Consultation Response from: KC Environmental Health (Pollution & Noise Control)		
2020/90441 - Pennine Service Station, Bradley Road, Bradley, Huddersfield HD2 1QD		
Discharge conditions 3, 6, 7, 18 on previous permission 2019/92233 for erection of petrol filling station, including new shop building, canopy, jet-wash and below ground storage tanks		
Date Responded: 14 Aug 2020	Responding Officer: Richard Hume	Responding Ref: WK/202003872
Condition 6 – Artificial lighting scheme In our previous responses dated 13 Feb & 7 Jul 2020 we recommended that condition 6 was not discharged because the information submitted by the applicant did not provide the information that was required by the condition. An email from Richard Shinn dated 4 August 2020 has now been received providing additional information and some clarification of the information previously submitted. In terms of the specific requirements of condition 6. 1. The proposed design level of maintained average horizontal illuminance for the site. In the email there is now a reference to guidance in BS EN 12464-2:2014 <i>Light and lighting — Lighting of work places Part 2: Outdoor work places</i>. He refers to Table 5.6 for fuel f

SBO04122019_Pennine_V3

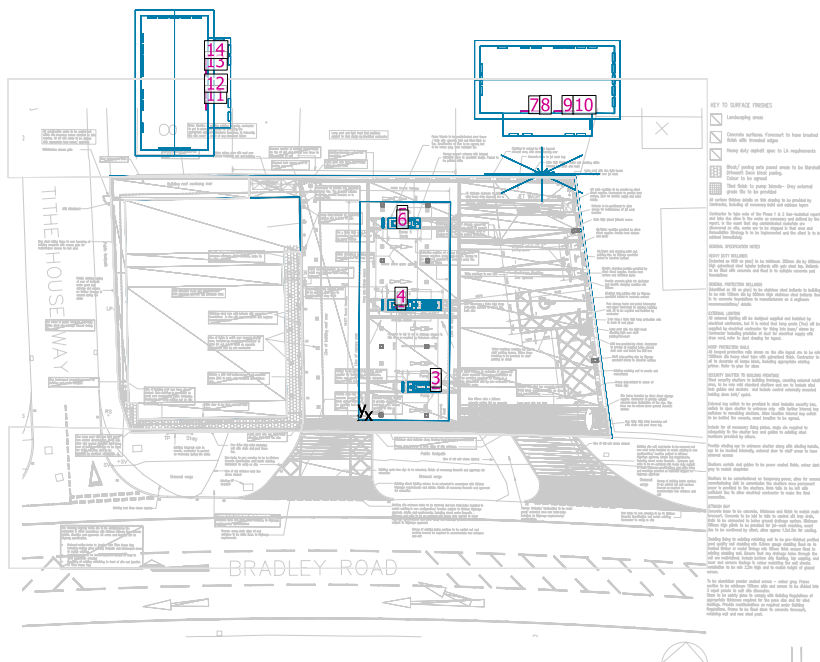
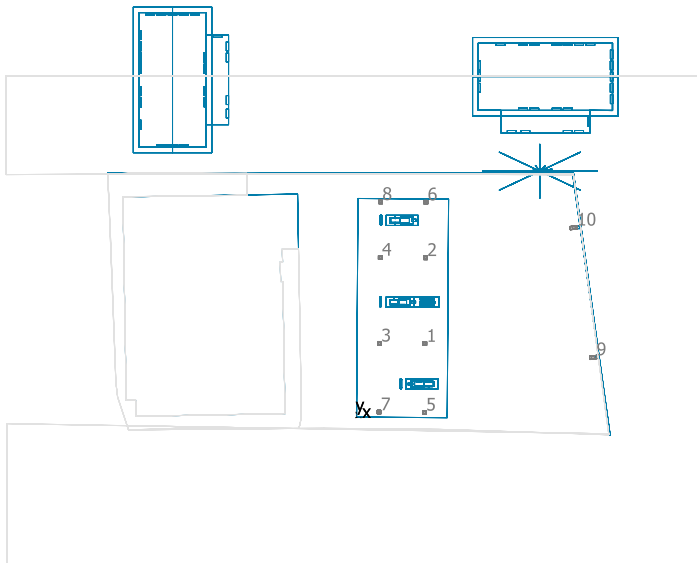
properties are at or below 1 lux. This is assumed to mean that the proposed lighting will not cause vertical illuminance at windows of nearby properties greater than 1.0 lux and based on that assumption is acceptable.

There is no reference to glare in either the email or the submitted scheme. However, the lighting underneath the canopy is unlikely to cause glare at neighbouring properties.

Despite condition 6 being clear about what information was required, the submitted information has been particularly difficult to interpret. However based on the assumptions mentioned above I consider that the proposed lighting is not excessive and will not have a significant adverse impact on nearby residents therefore I recommend that the revised Lighting Scheme by Bever Innovations dated 4 Dec 2019 (with ref: SBO04122019_Pennine_V3) is accepted.

The lighting needs to be installed and thereafter maintained in accordance with that lighting scheme.
